# ENG-CDR21013-R2-GEC.pdf Markup Summary

Department of Public Works

C101

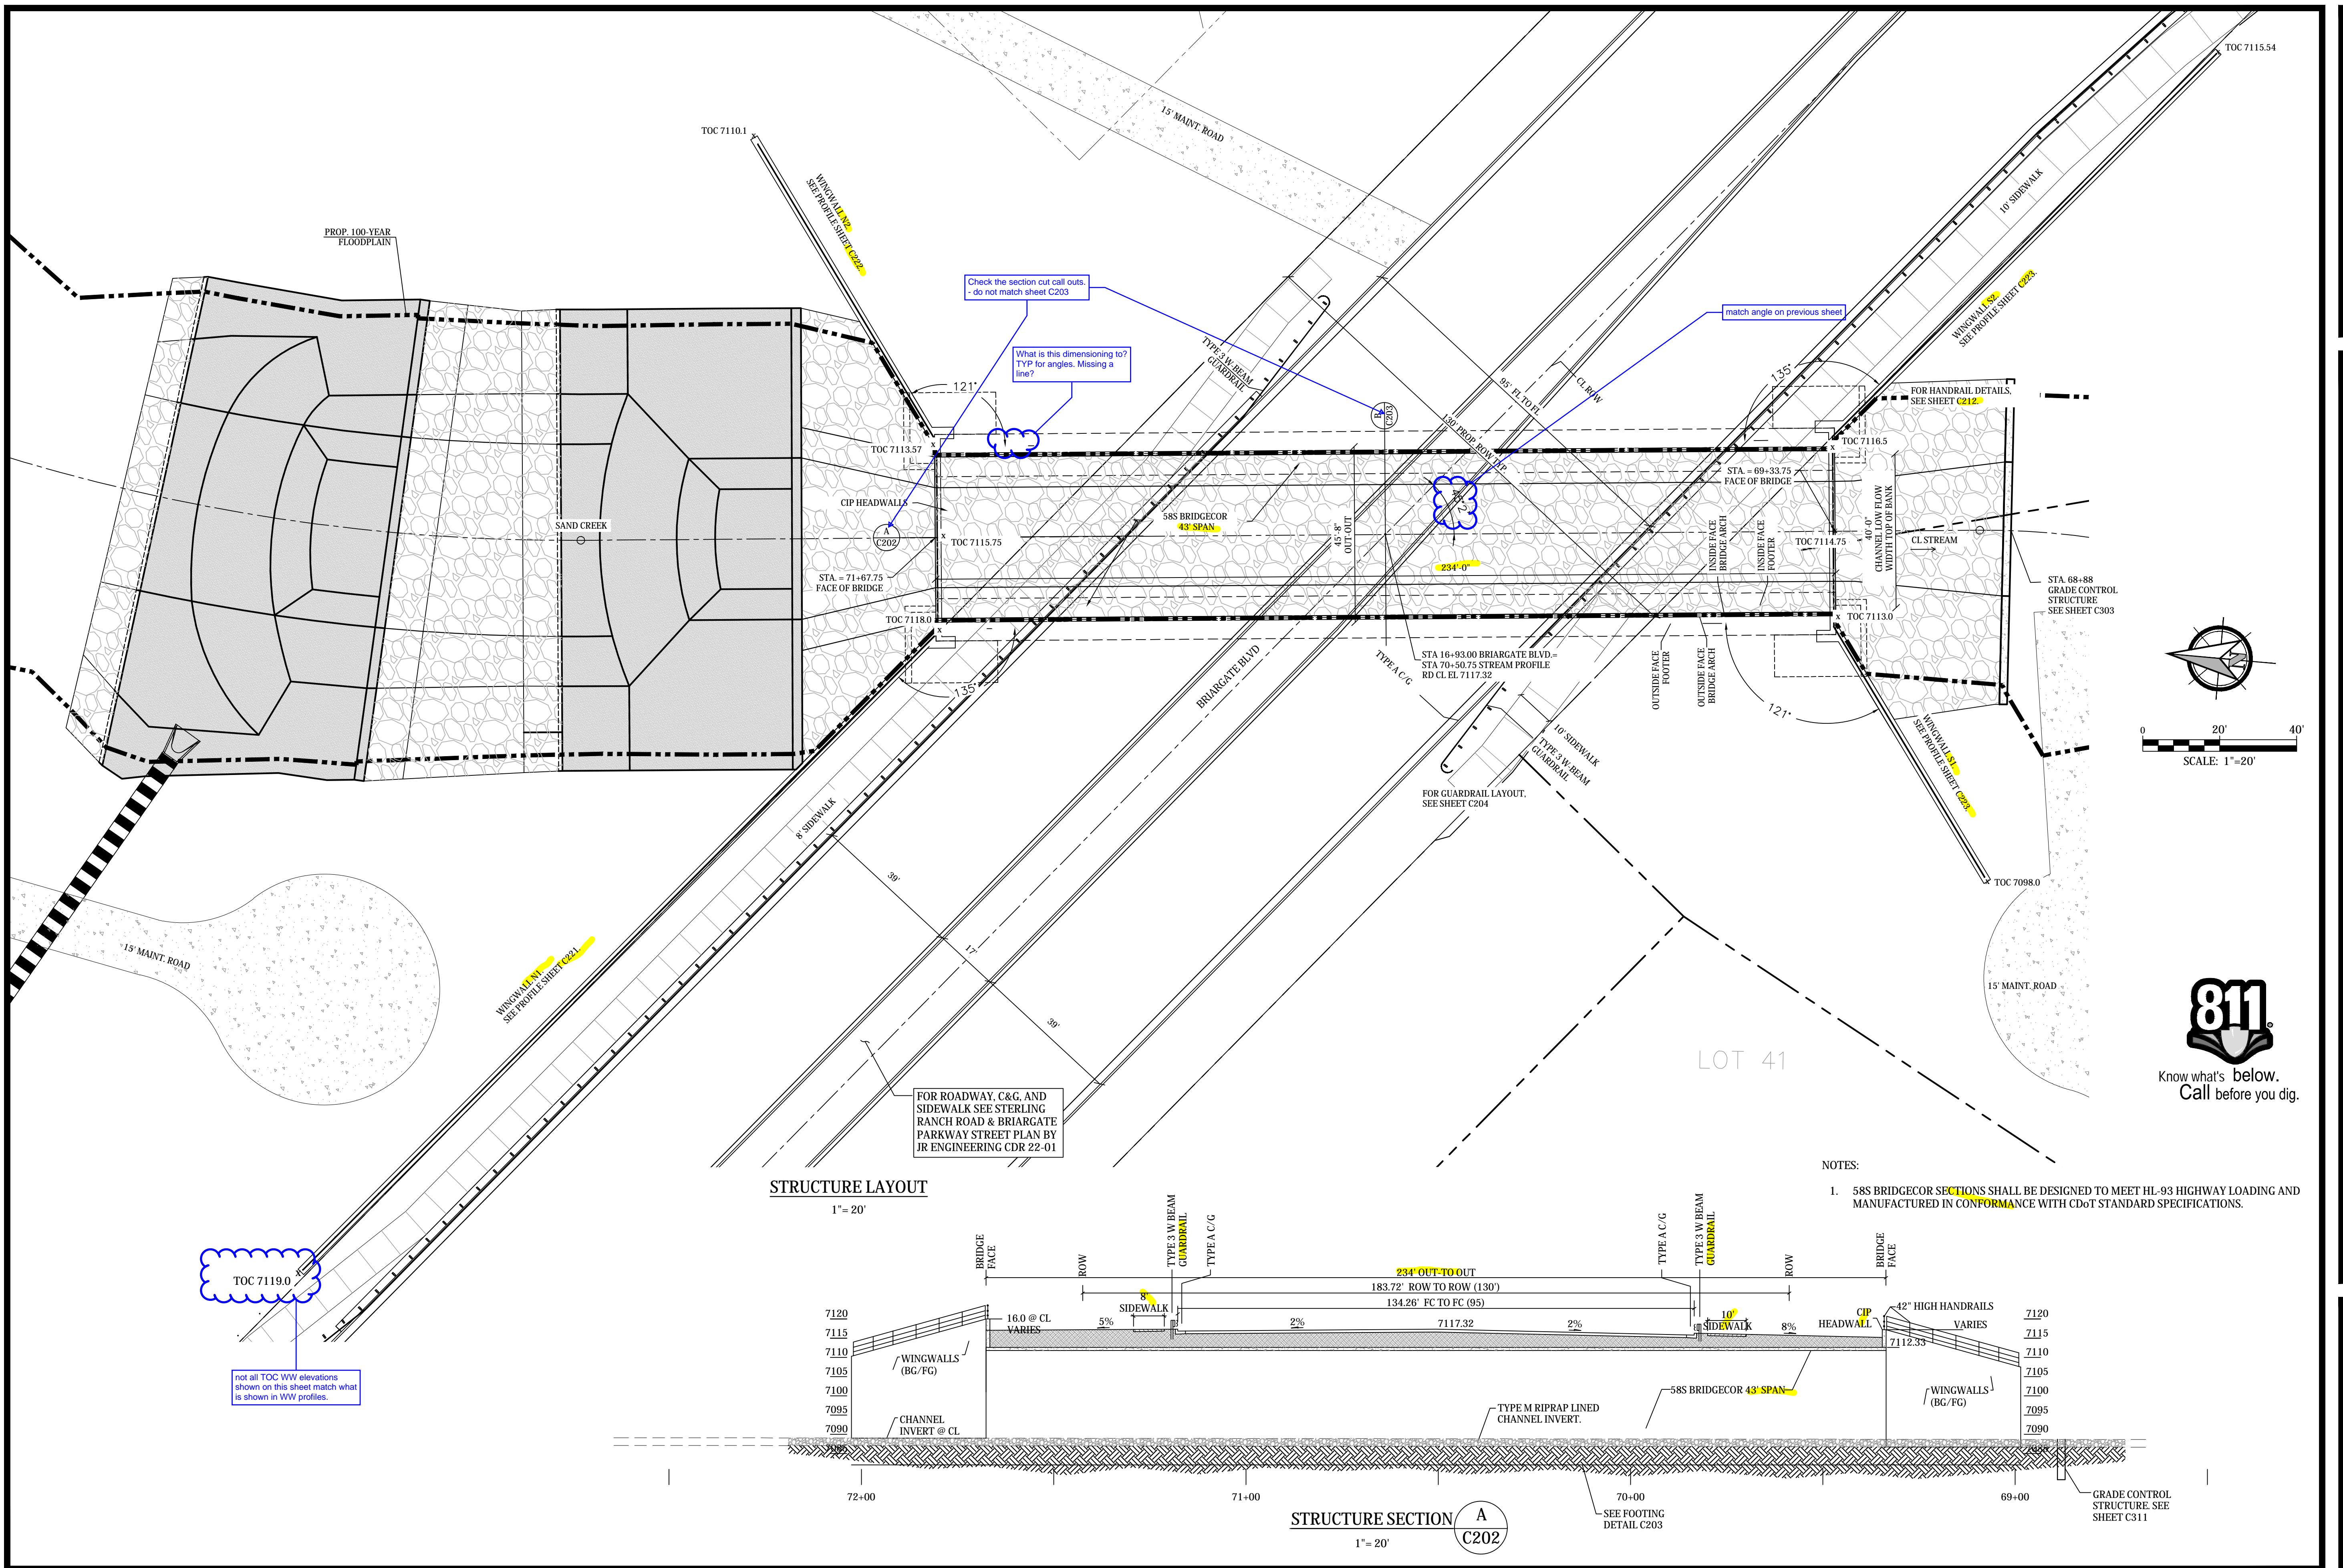
Show VTC?

If the curb and gutter and final grading is by others, reference those plans. This set of plans should only show what is being done with the bridge construction.
